# CITY OF ALBUQUERQUE

March 6, 2019

**RE: Champion Xpress Car Wash  
4516 Wyoming Blvd. NE  
Grading and Drainage Plan  
Engineer's Stamp Date: 02/15/19  
Hydrology File: F20D005**

C-3.0

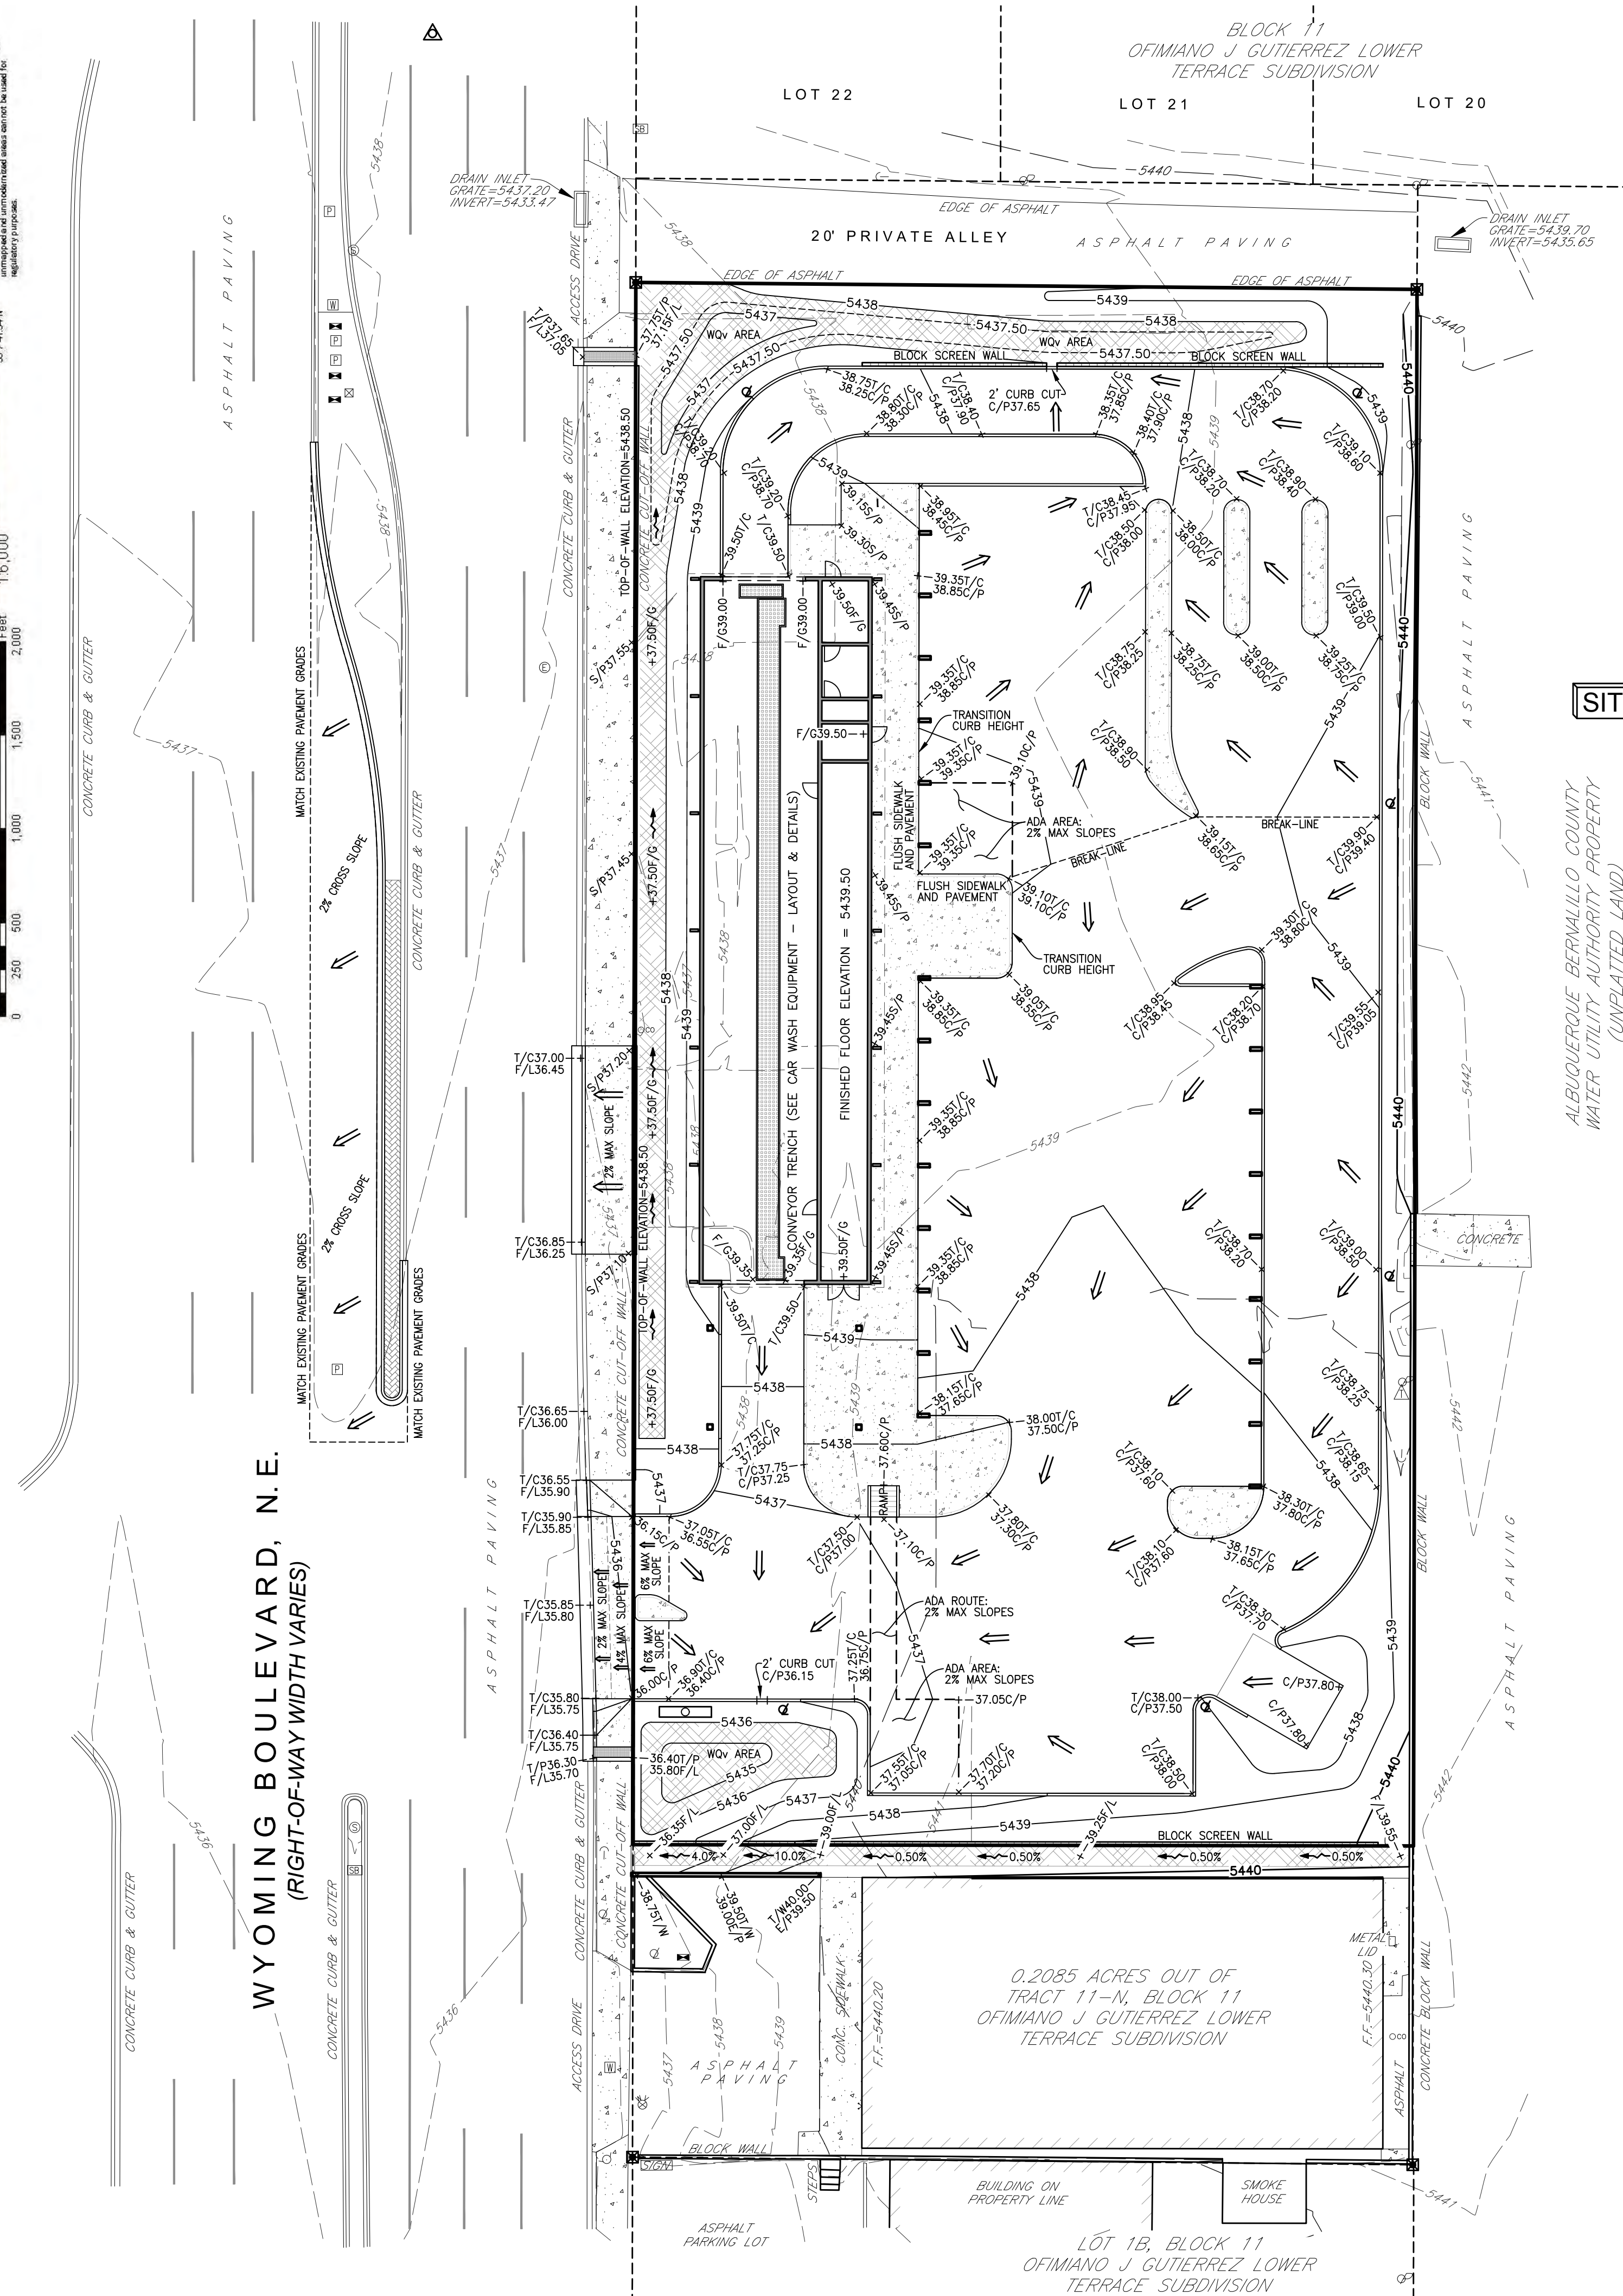
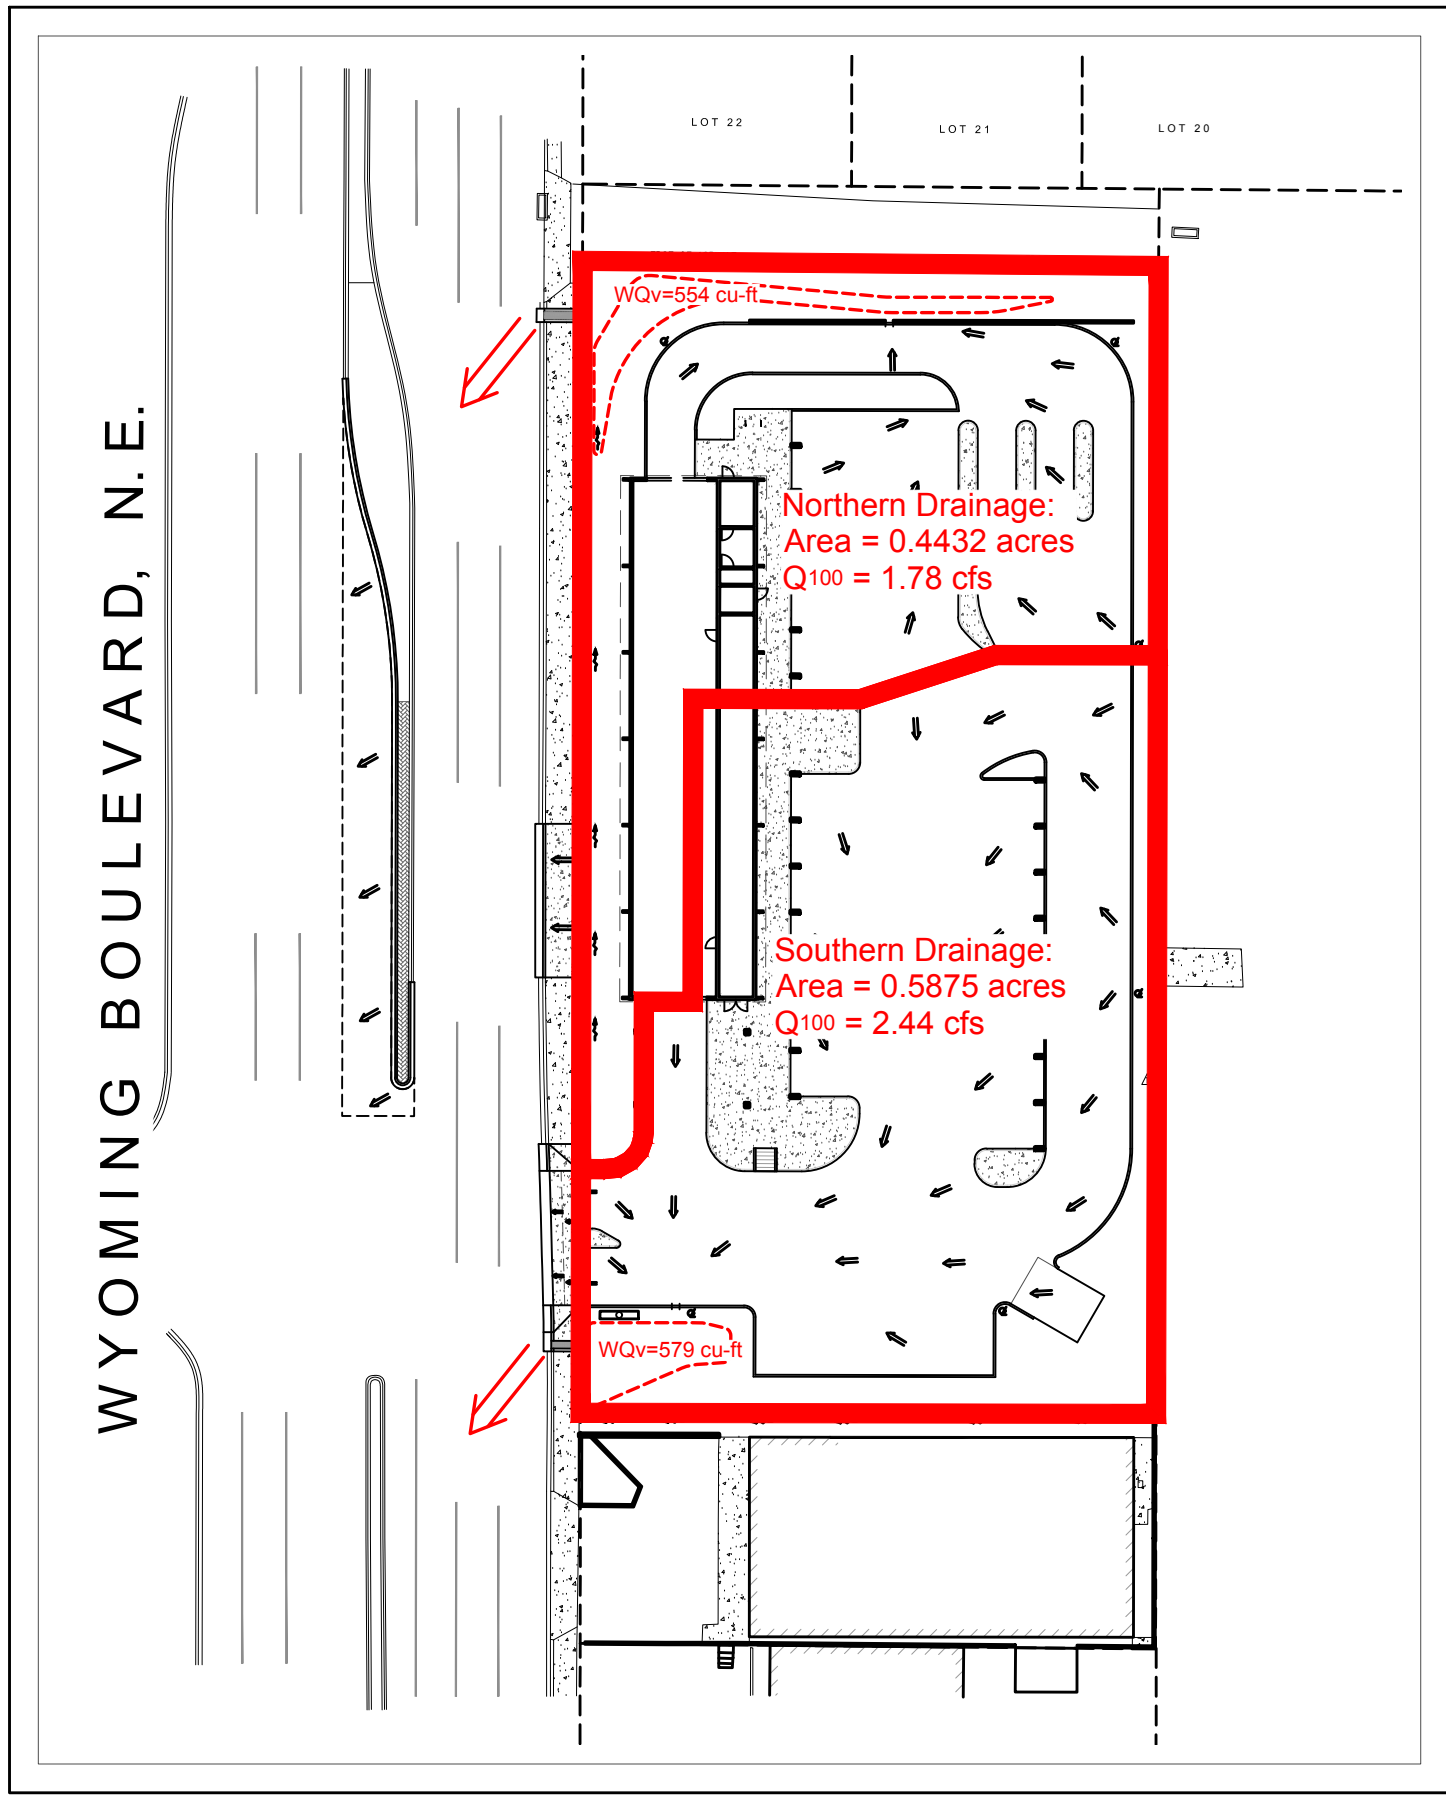
3. Please provide the legal description of the property. Please refer to the DPM Chapter 22 Section 7 - Grading Plan Checklist.
4. Please provide the proposed grades or existing grades on both sides of the proposed retaining walls.

7. This site appears to have two drainage areas. Please show them and provide the drainage calculation for each drainage area.
8. This site has an existing building and parking area. Therefore the amount of Type D (impervious needs to be estimated) and Type B (landscape area). This site also has free discharge into Wyoming Blvd. Therefore no detention will be required for this site. See aerial image below.

9. Per the City's Drainage Ordinance, this site is required to manage the storm water quality of the runoff. Since this site is a redevelopment, the storm water quality volume for each of the two drainage areas are calculated by multiplying the impervious area (SF) of the drainage area by 0.26 inches. This can be placed within the landscape area however; drainage from the impervious area must first drain to the storm water quality pond prior to discharging into Wyoming Blvd. Please provide the calculations.

10. Both drainage areas typically discharge into their storm water quality pond via curb cuts. Please provide the weir calculations for the curb cuts and indicate the size of the curb cut (typically this is either 1' or 2').

11. Please provide the required water quality volume and the provided water quality volume for each pond.
12. Each storm water quality pond will discharge to Wyoming Blvd through a sidewalk culvert. Please provide wier calculation (Chapter 22 of the DPM) for the proposed sidewalk culverts.

14. Since sidewalk culverts are needed, please add the SO-19 Permit Notes to the Grading & Drainage Plan. See Attachment.
15. Please provide spot elevations at the beginning and end of all swales. Please also provide the slope of the swales.

DRAINAGE SWALE SECTION
ALONG WYOMING BOULEVARD FRONTAGE
NOT TO SCALE

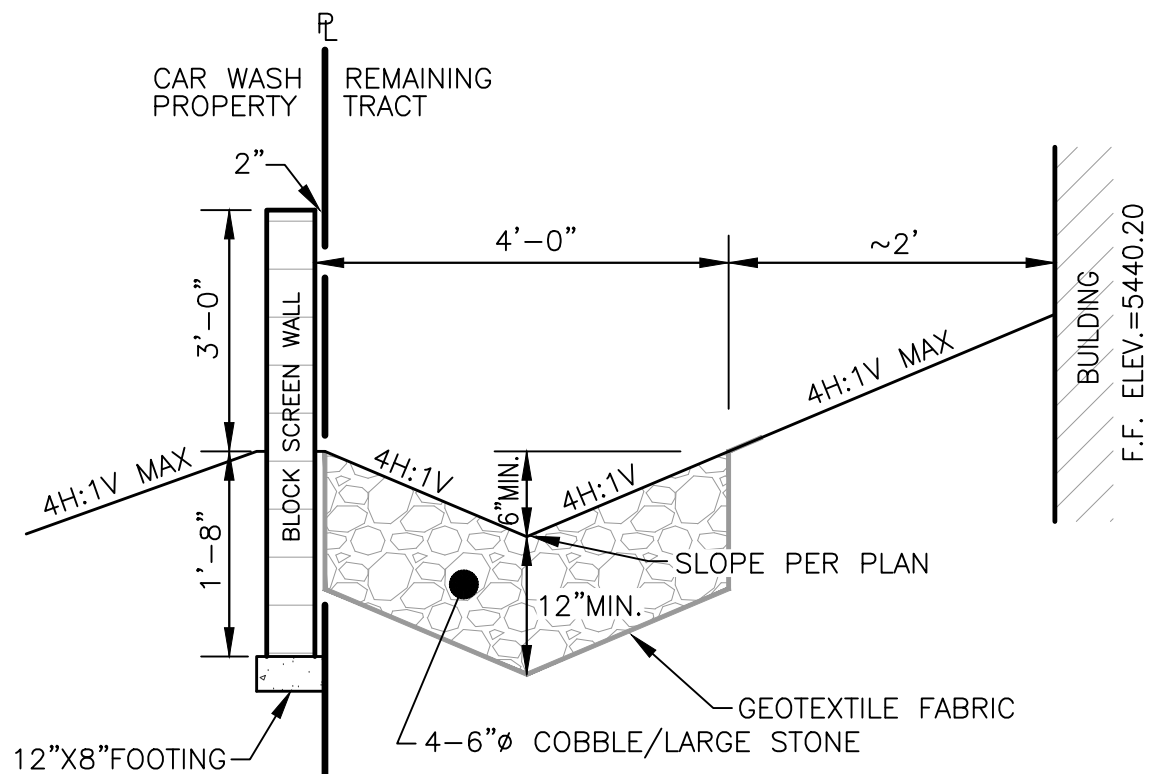
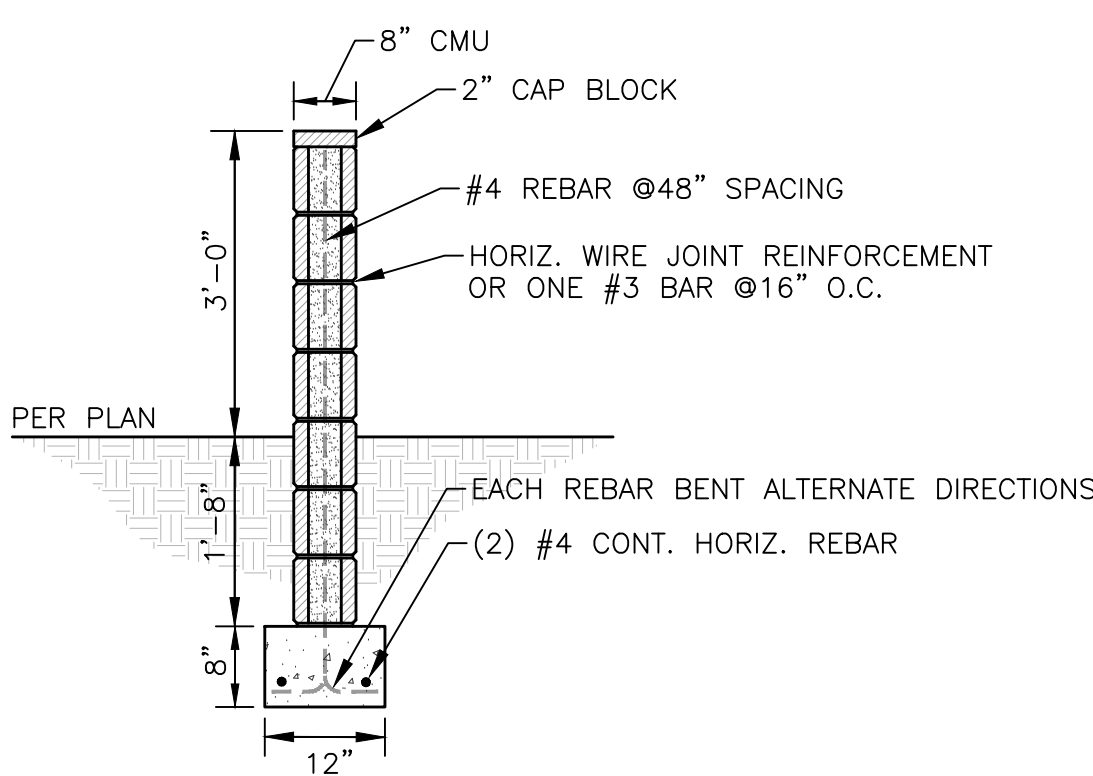
16. Please provide a written agreement with the adjacent property owner in order to construct the proposed swale on that adjacent property. Also the discharge of this swale will need to go through a sidewalk culvert.
